**CITY OF PORTLAND**

April 4, 2002

RE: 1476 Washington Avenue – R-3 zone – 347-C-039

CITY OF PORTLAND
ASSESSORS PLAN
SCALE 1"=50'

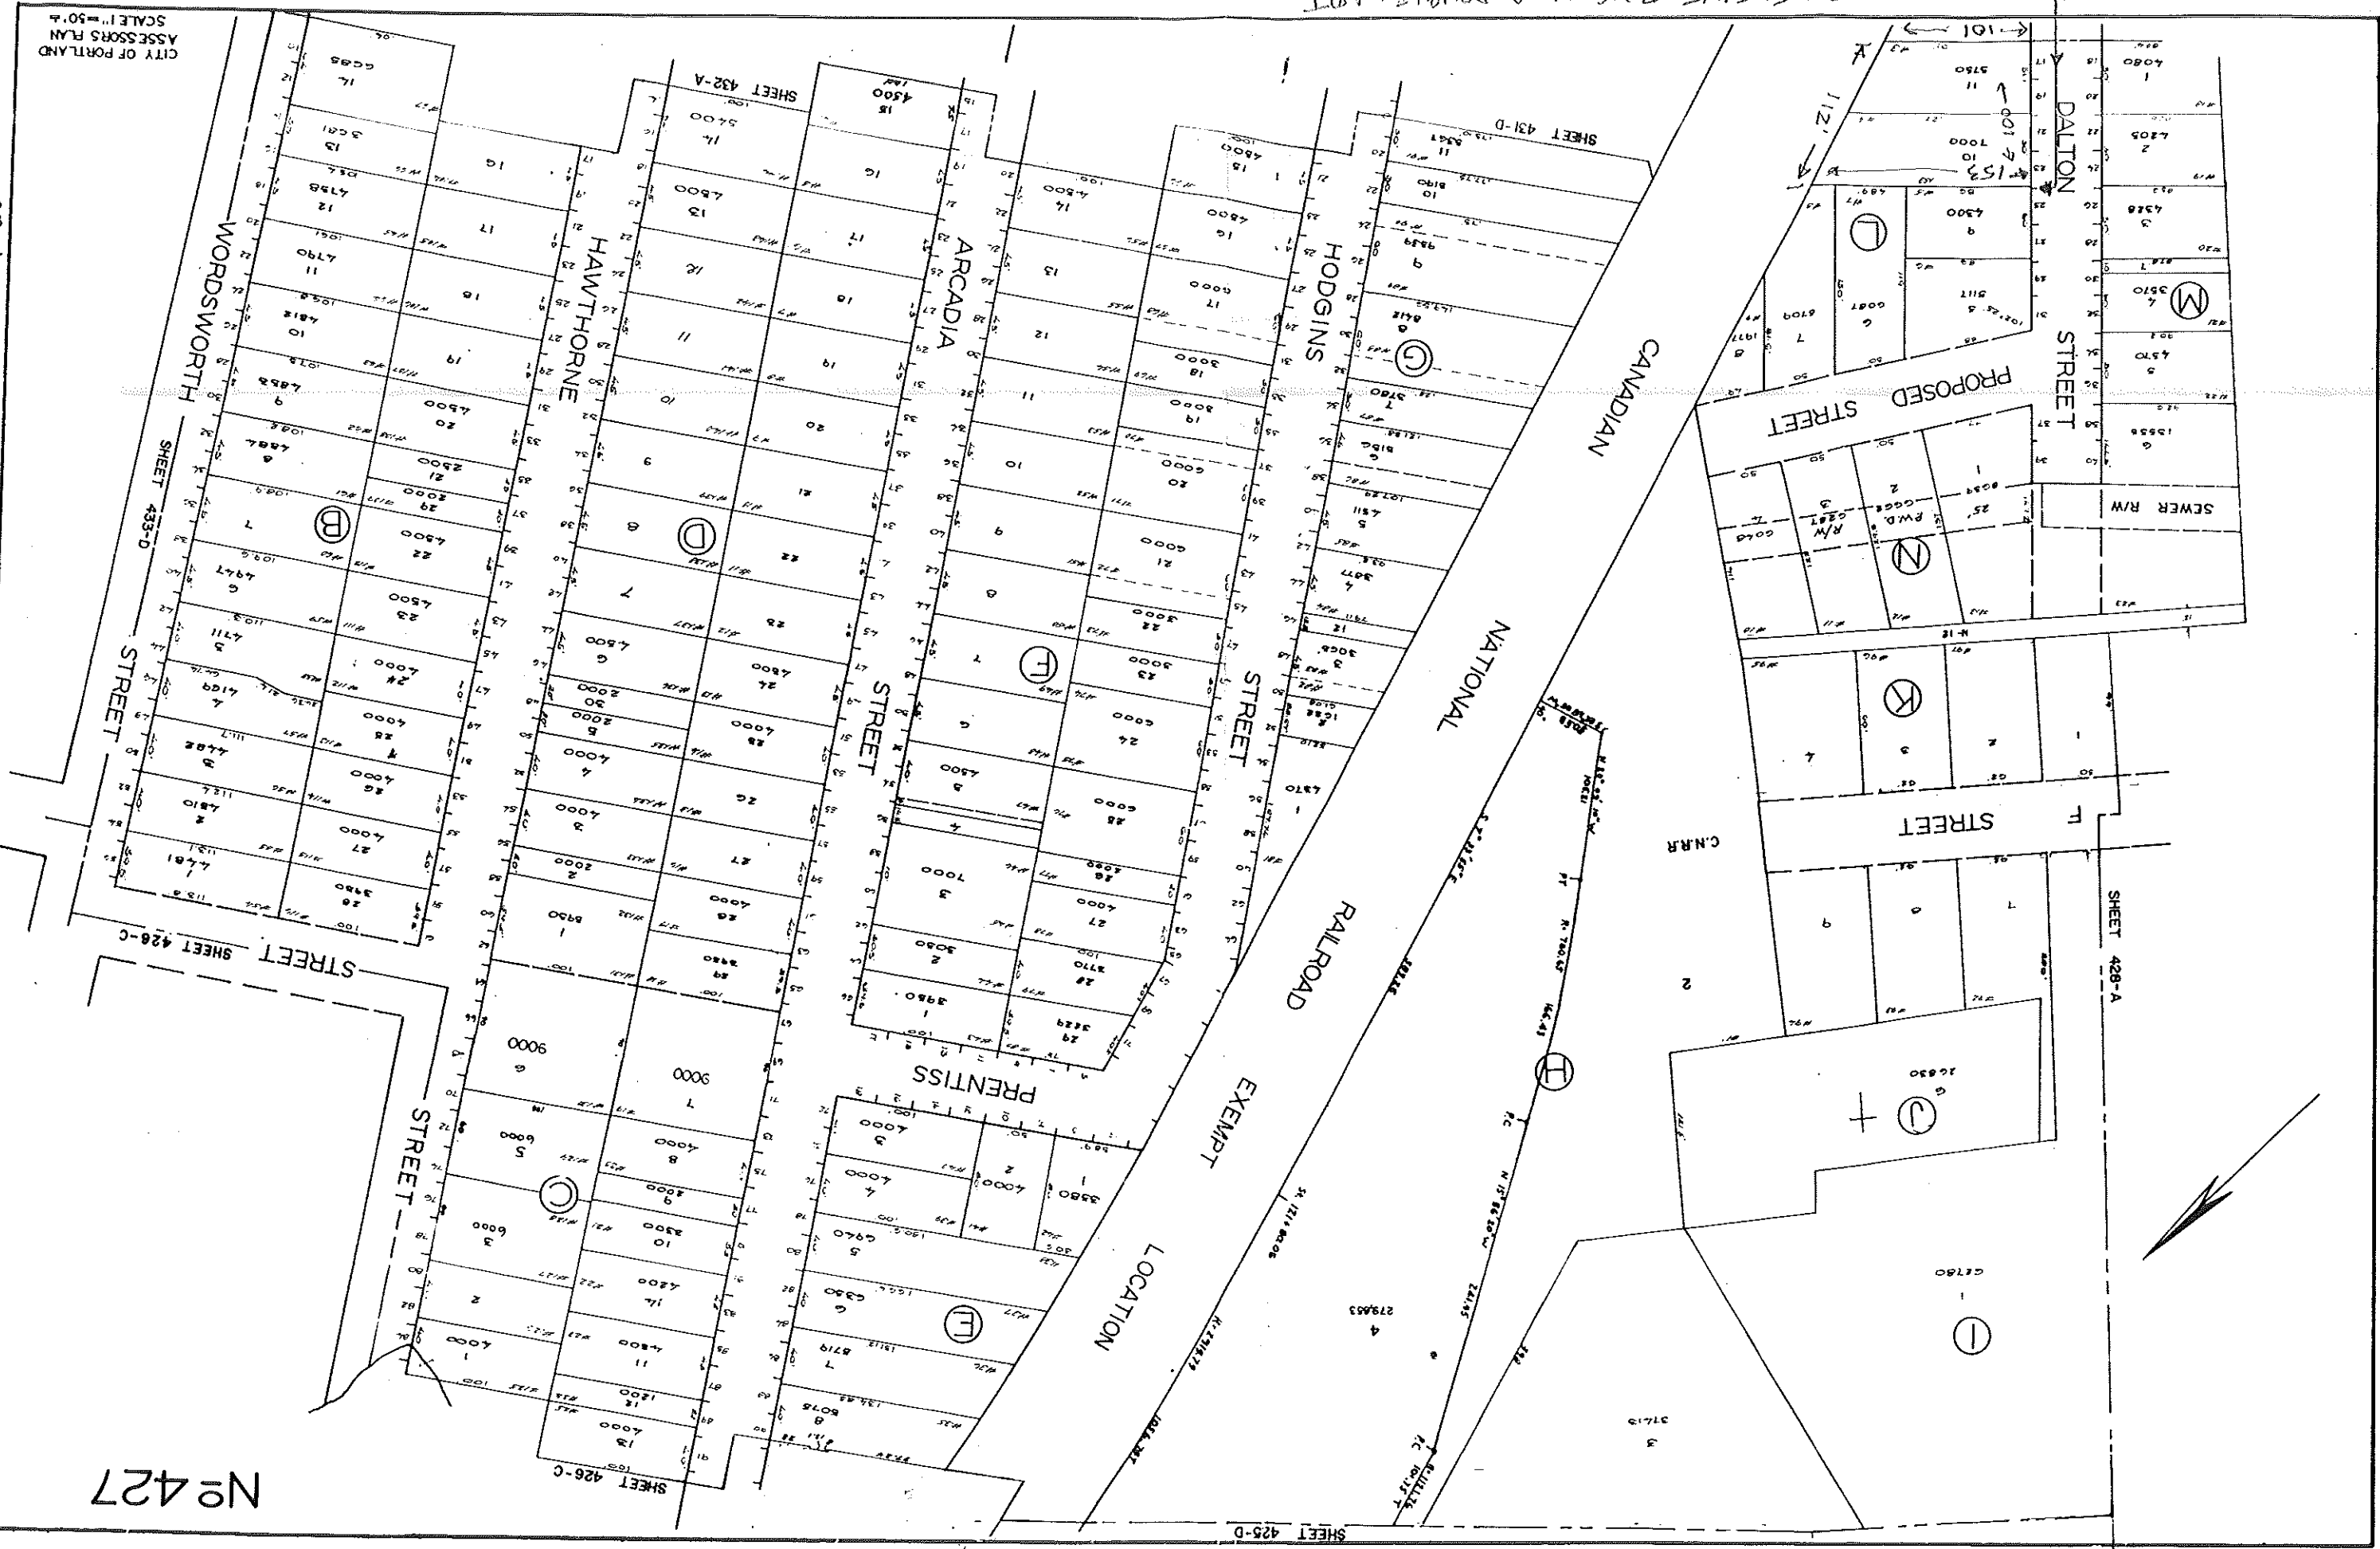
I will also need an accurate site plan. The one that was submitted can not be accurate. The rear setback given on this plan shows 150’ from the rear of the building to the rear property line. The Assessor’s plans show the entire lot to be 150’ deep. Therefore the setback can not be the same length.
